New driveway and vehicular access to eastern boundary of property. Resubmission following EP/143/13.

Middle Barn The Street East Preston

Thank you for your internet representation made on 1st July 2014 which has been recorded as 'an objection' with the comments as follows:

PROPOSED ELEVATION 1:100

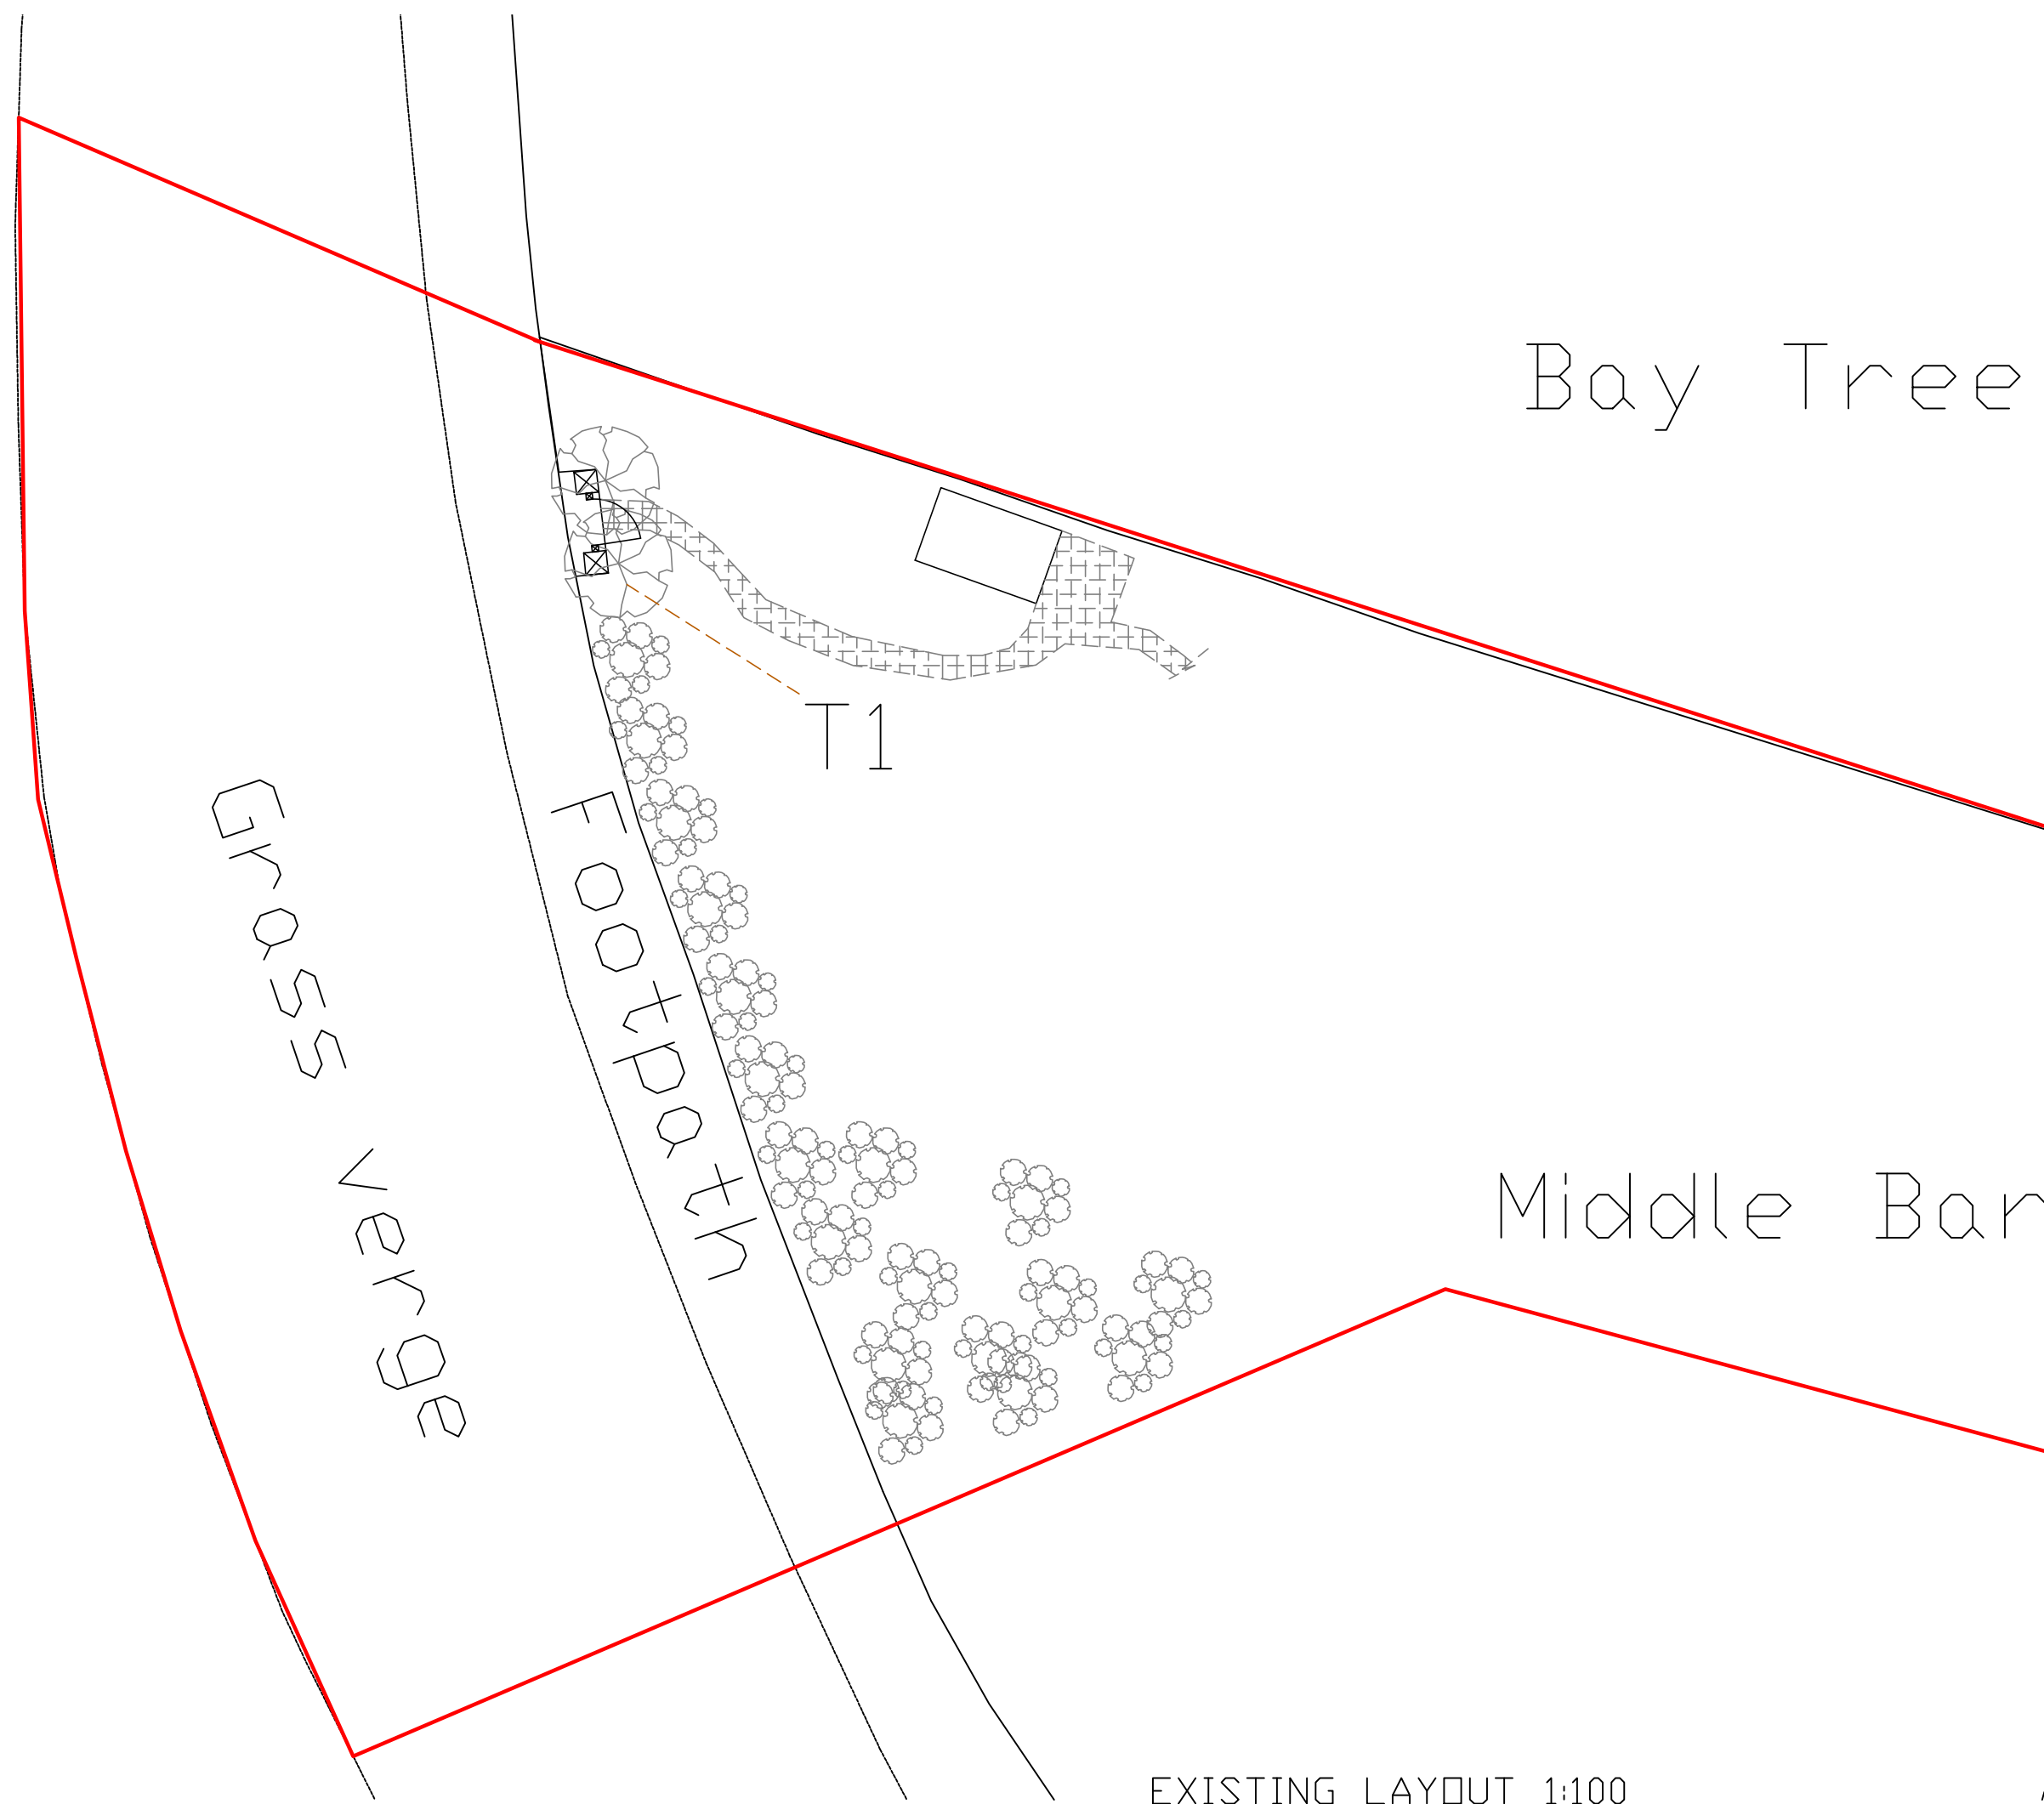
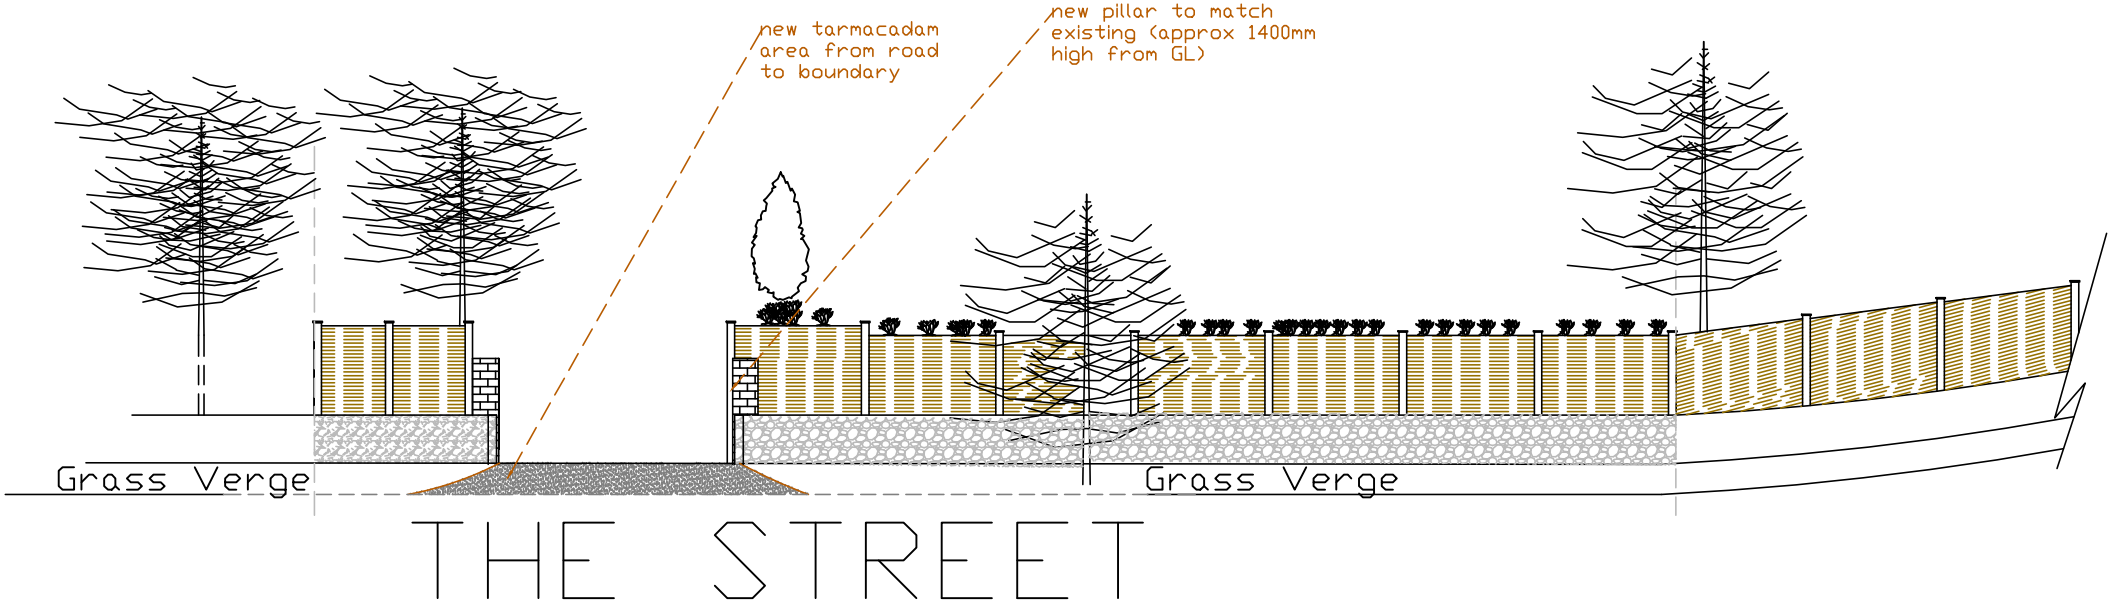
The proposed new entrance and tarmac drive across the grass verge outside Middle Barn would have a severely adverse effect on the street scene and the amenities of East Preston. It would also affect the setting of a building on the Local List of Buildings of Character. The drive would cross the wide grass verge near the apex of a bend, where its impact would be greatest. The flint wall behind provide an appropriate frontage to the three converted barns, and its appearance would be harmed by a breach to provide the new entrance. The scar on the grass verge and breach in the boundary wall are on one of the main entrance routes to the village centre.

Flint front boundary walls and grass verges are both features of especial value in East Preston. The draft Neighbourhood Plan emphasises the importance of preserving front boundary walls and other features that contribute to the street scene in this part of the village (Character Area 3); The East Preston Village Design Statement emphasises the importance of preserving verges in this area. Middle Barn is on the Local List of Buildings of Character; policy GEN22 states that development that would adversely affect the setting of such buildings will not be permitted. The breach in the front wall and scar on the verge would adversely affect the setting of Middle Barn.

PROPOSED LAYOUT 1:100

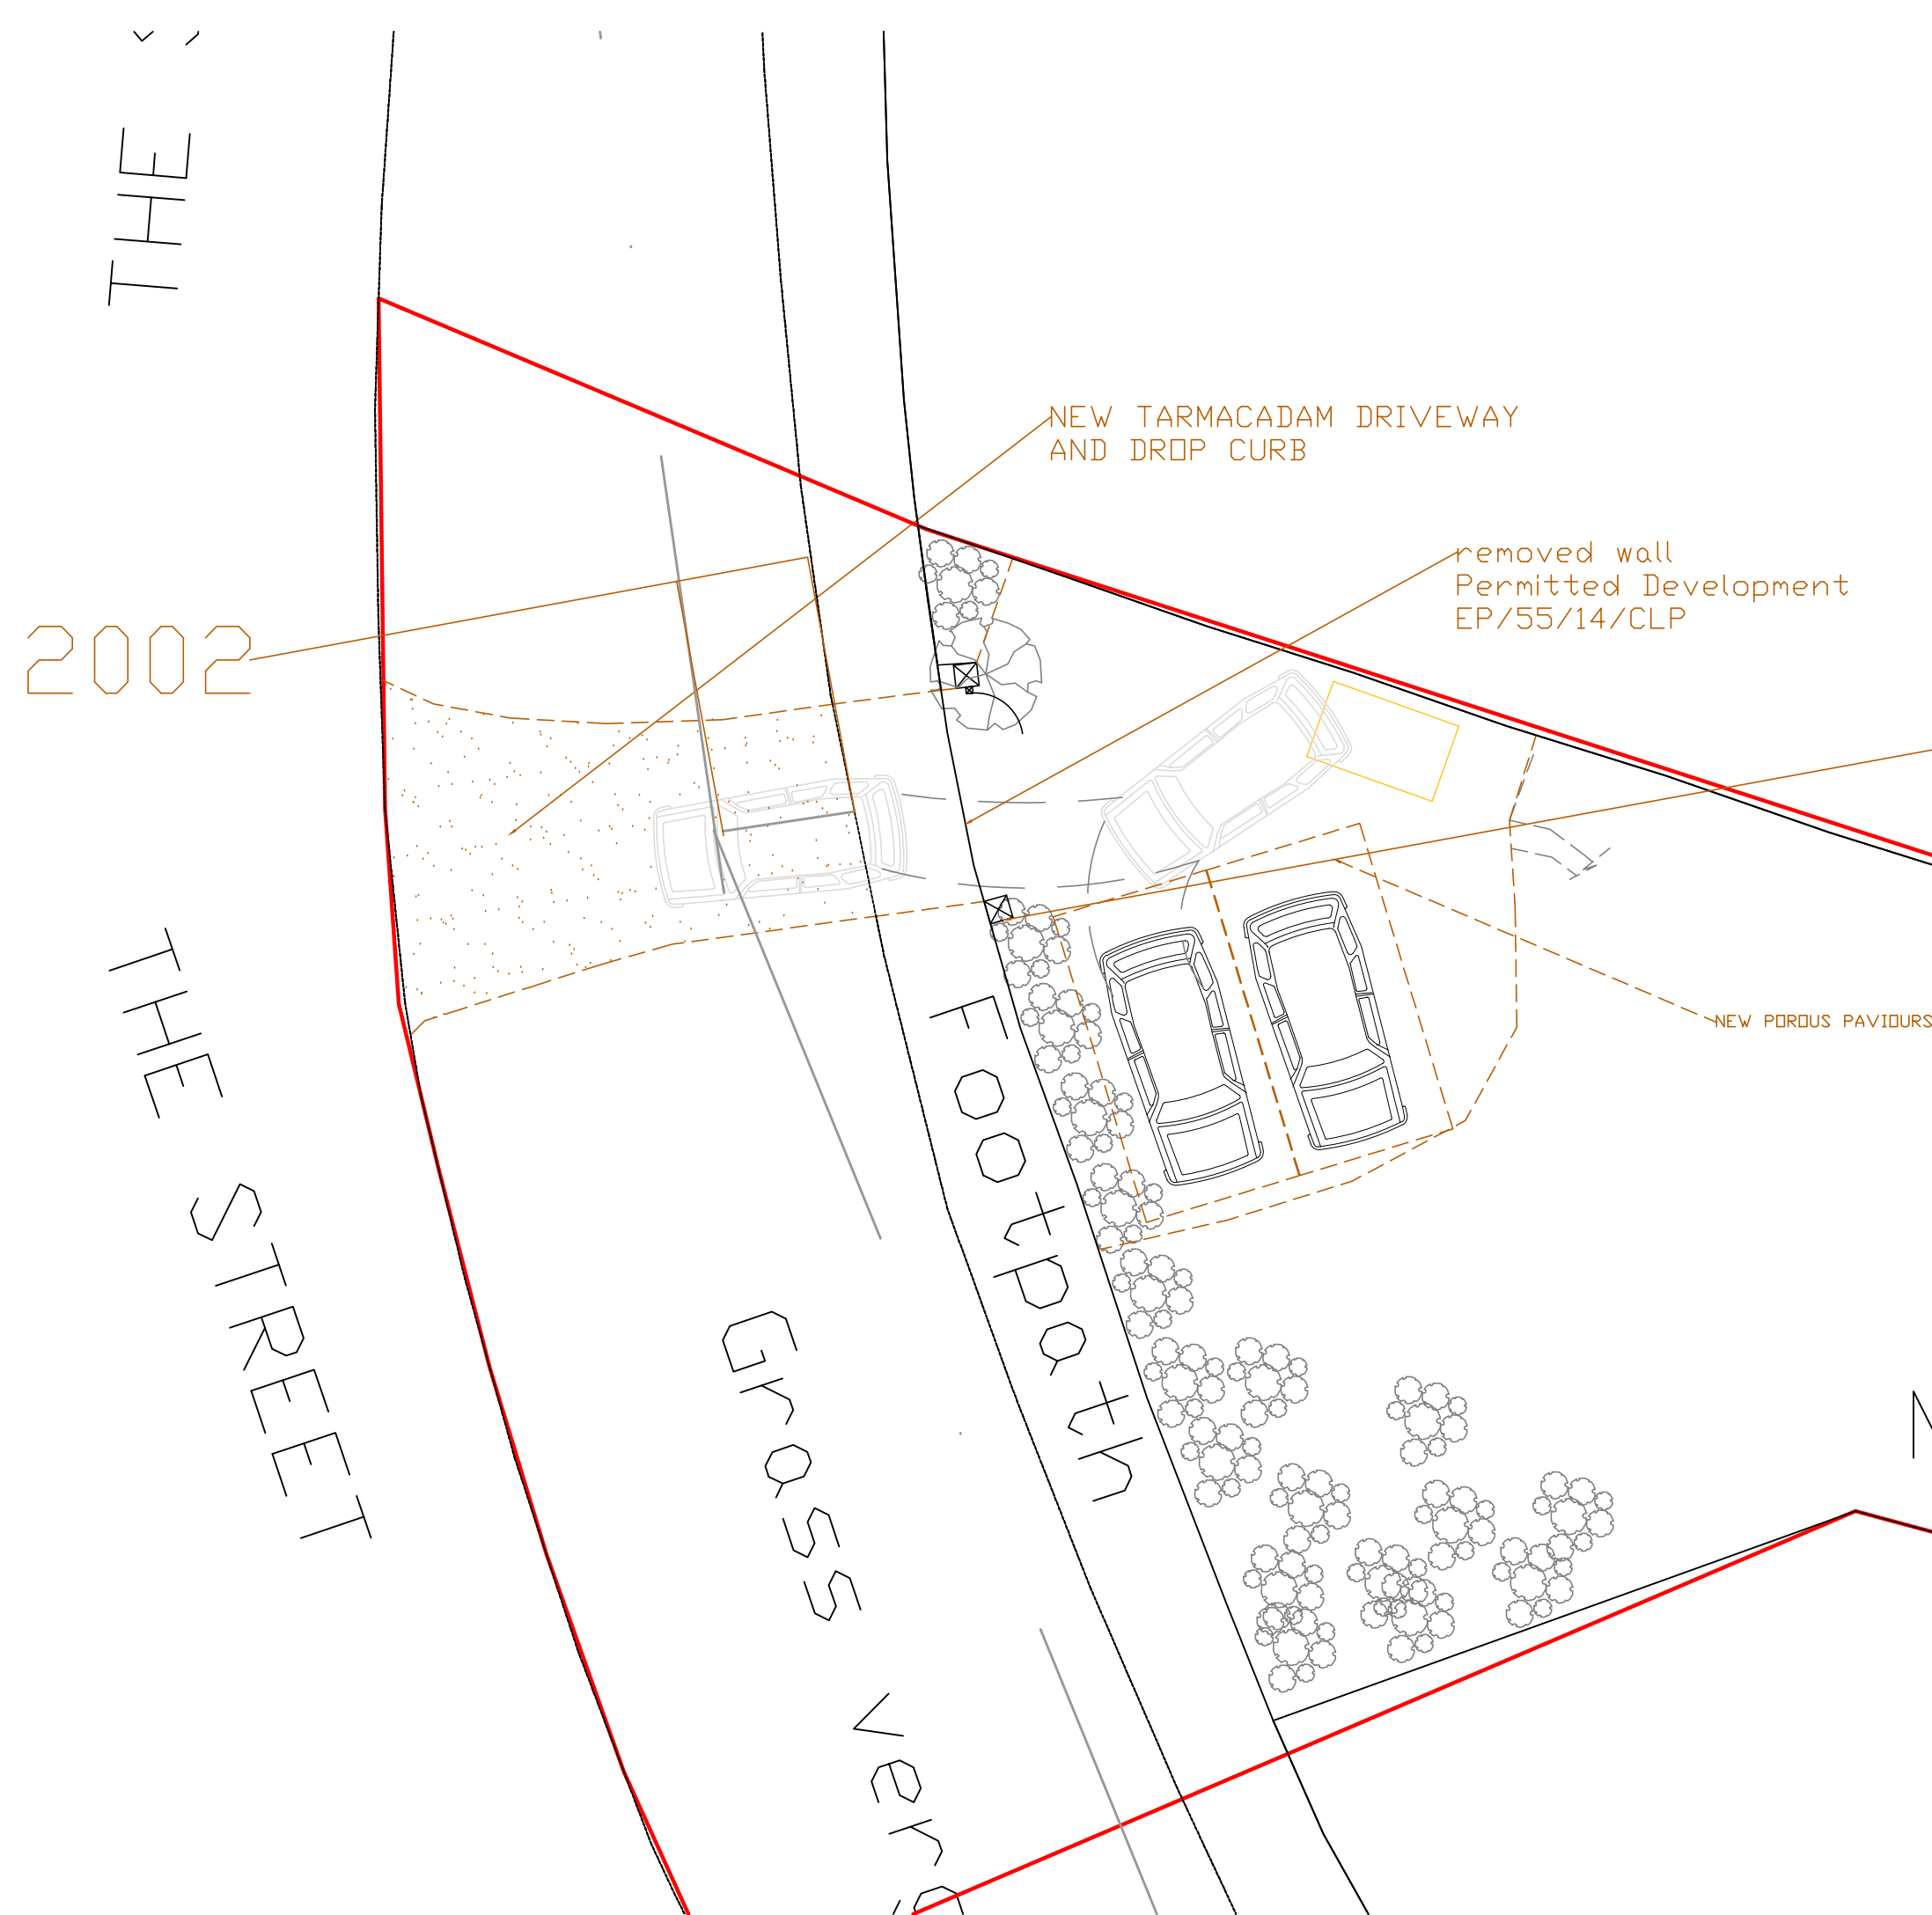
Visibility to the north from the proposed entrance is obstructed by a low-growing tree, which is not marked on the plan of the scheme. There would therefore be safety implications if it was built.
